From: Rico Spugnardi
To: ssmall2@maine.rr.com
Cc: [Gordon Johnson](mailto:Gordon.Johnson)
Sent: Friday, January 10, 2014 4:25 PM
Subject: Mayfield Street, PO - Review of Water Service Conditions

This email is a follow-up to your request for review of the District's decision to require a water main extension to serve a new house on Mayfield Street. I have met with senior staff to discuss your project and to determine if it would be possible to instead serve the new property with a water service line as you have requested.

**GRADING PLAN**  
Project Name:  
**SINGLE FAMILY RESIDENCE**  
29 WAVERLY STREET, PORTLAND ME 04103

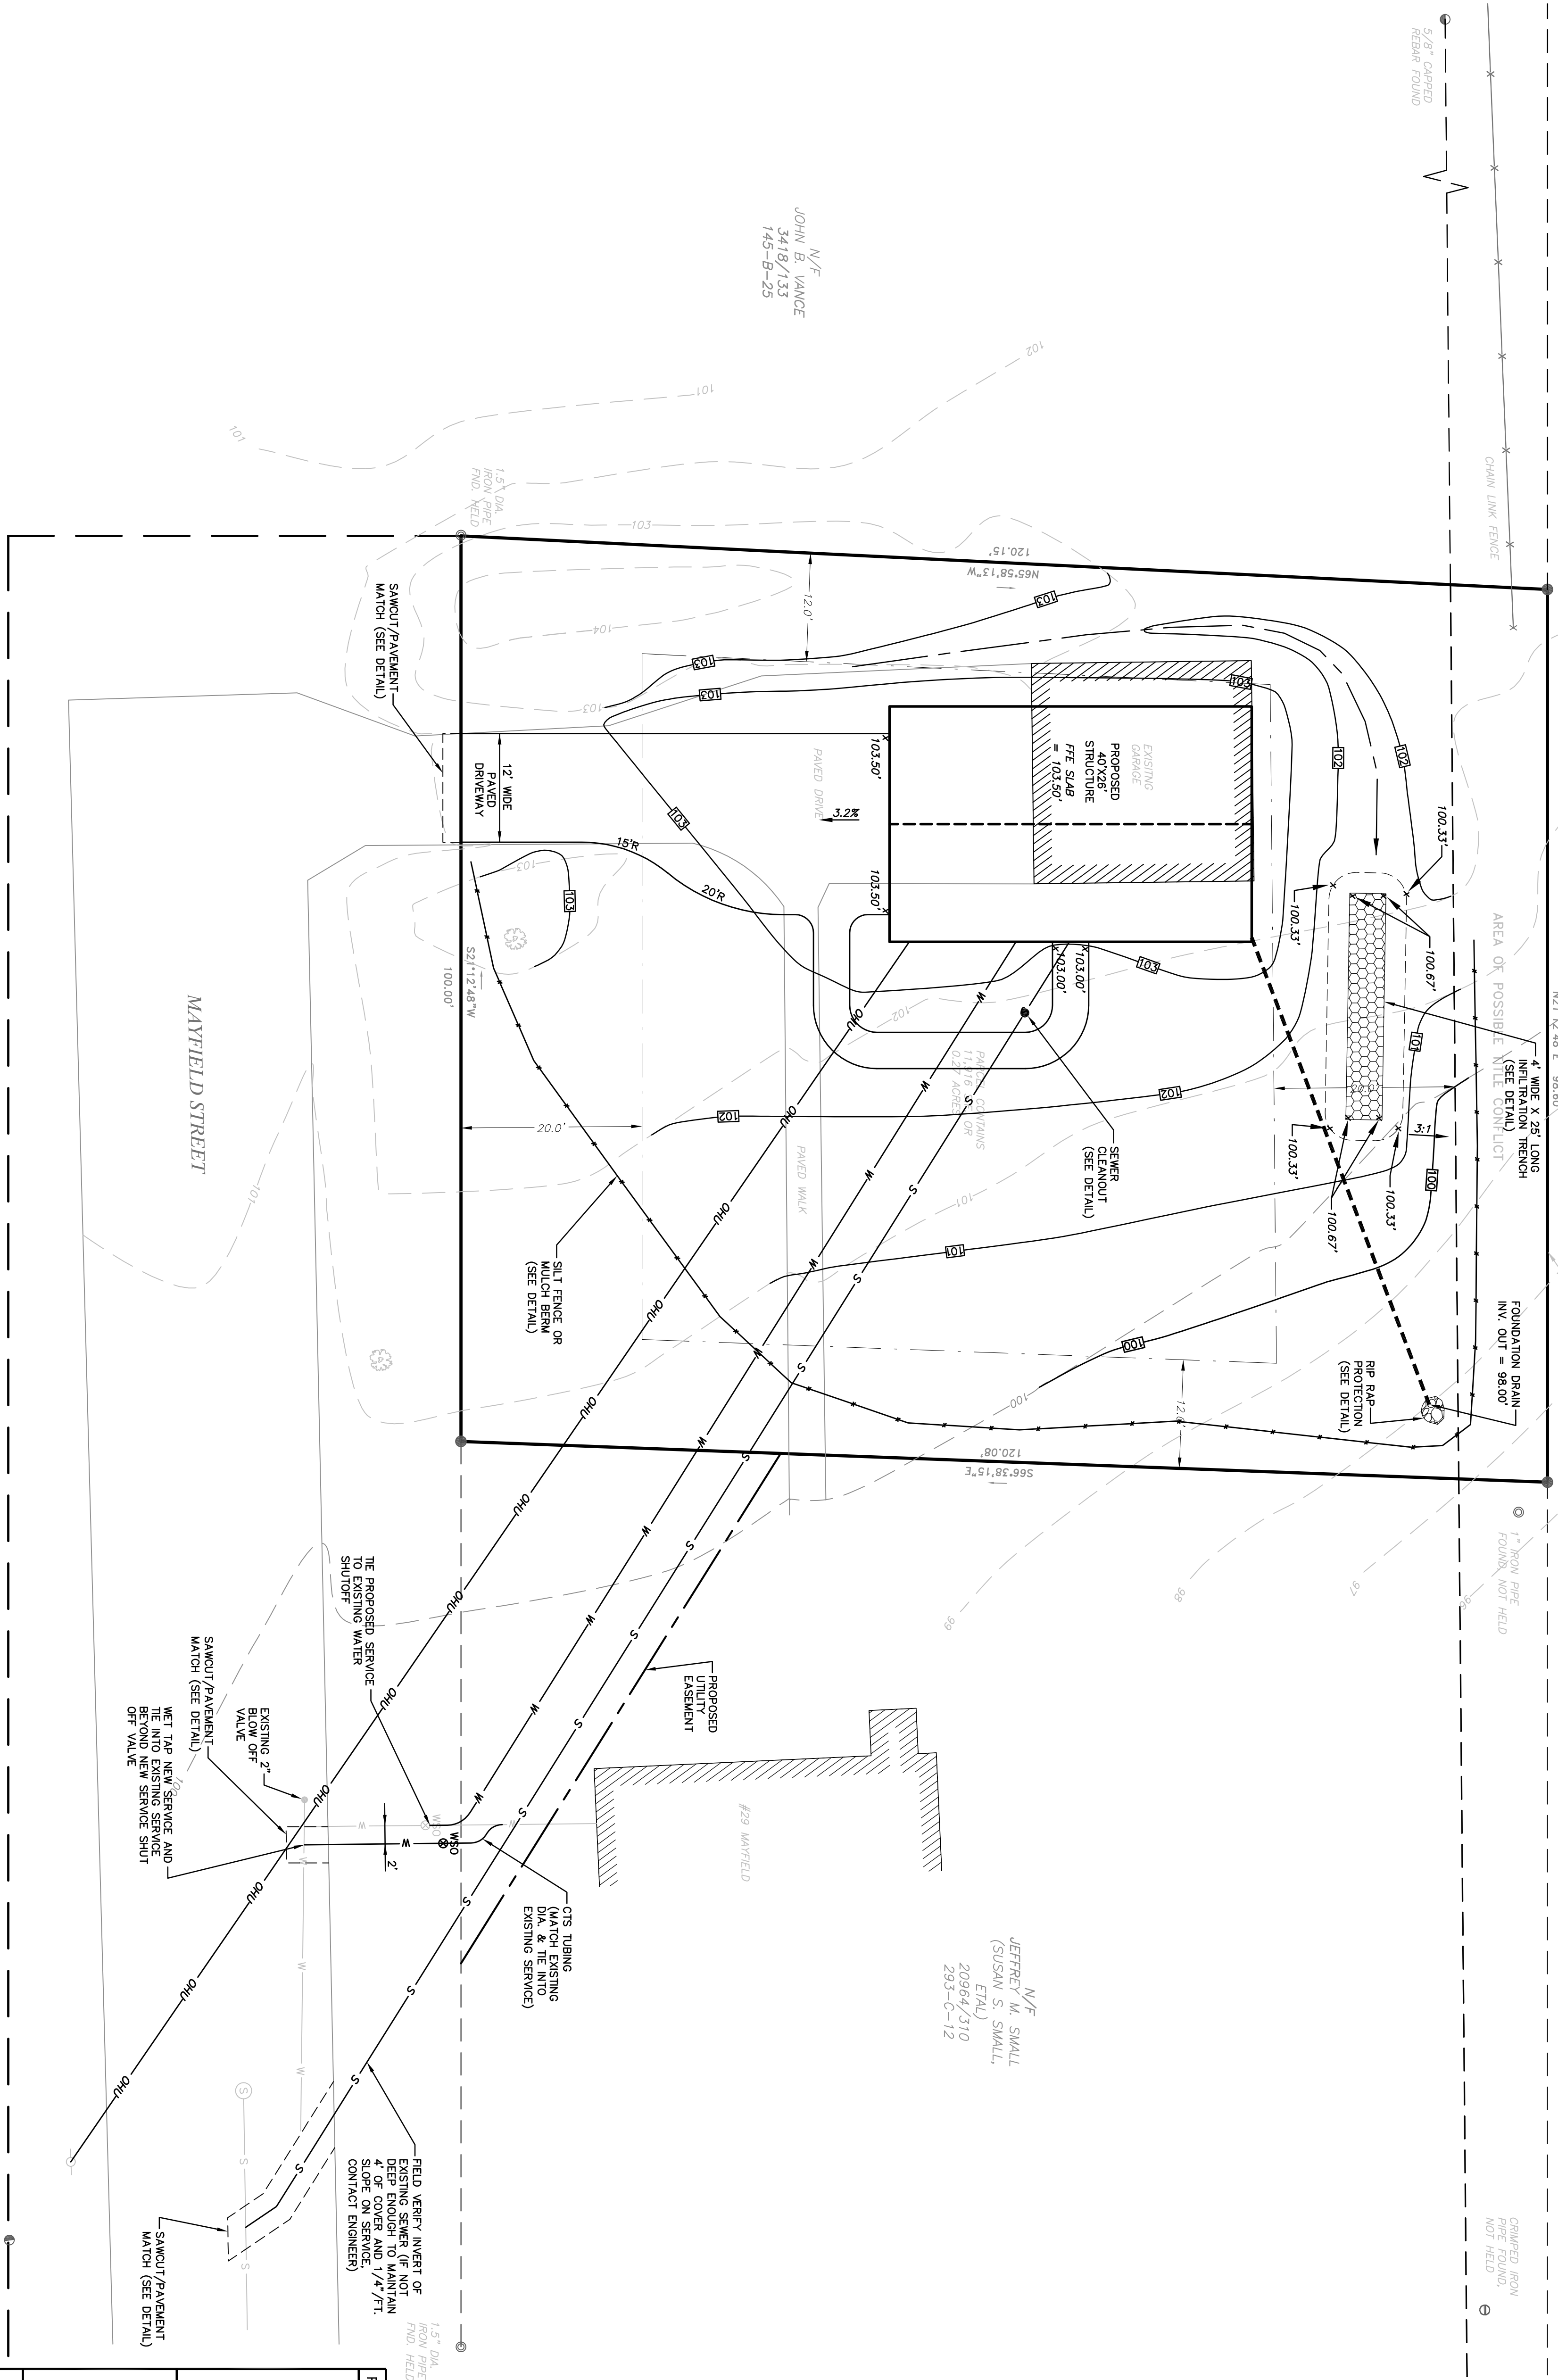
- 2) The design plan created by Northeast Civil Solutions must be modified as noted below to meet PWD specifications. We are happy to work directly with NECS on these comments to clarify any questions that they may have. Please feel free to send this along to the engineer as you see fit.

- a. The size of the new water service line must be noted on the plan. A 1" service line is typical for a new single family home, however a larger service line may be required to meet the needs of a residential sprinkler system. We recommend that you consult with the sprinkler system designer on the service line size needed and reflect that on the plan.

- b. The new water service line must extend perpendicularly from the existing water main to the property line prior to any bending of the service.

- c. The new water service line must be located at least five feet away horizontally from the blow-off valve at the end of the main.
- d. The new water service line must be located at least three feet away horizontally from the existing water service line to 29 Mayfield Street.
- e. The new water service line must be located at least five feet away horizontally from the sewer service line. An exception to this separation requirement is possible if the sewer service line is at least 18 inches deeper than the proposed water service line, in which case the horizontal separation may be as little as 18 inches.
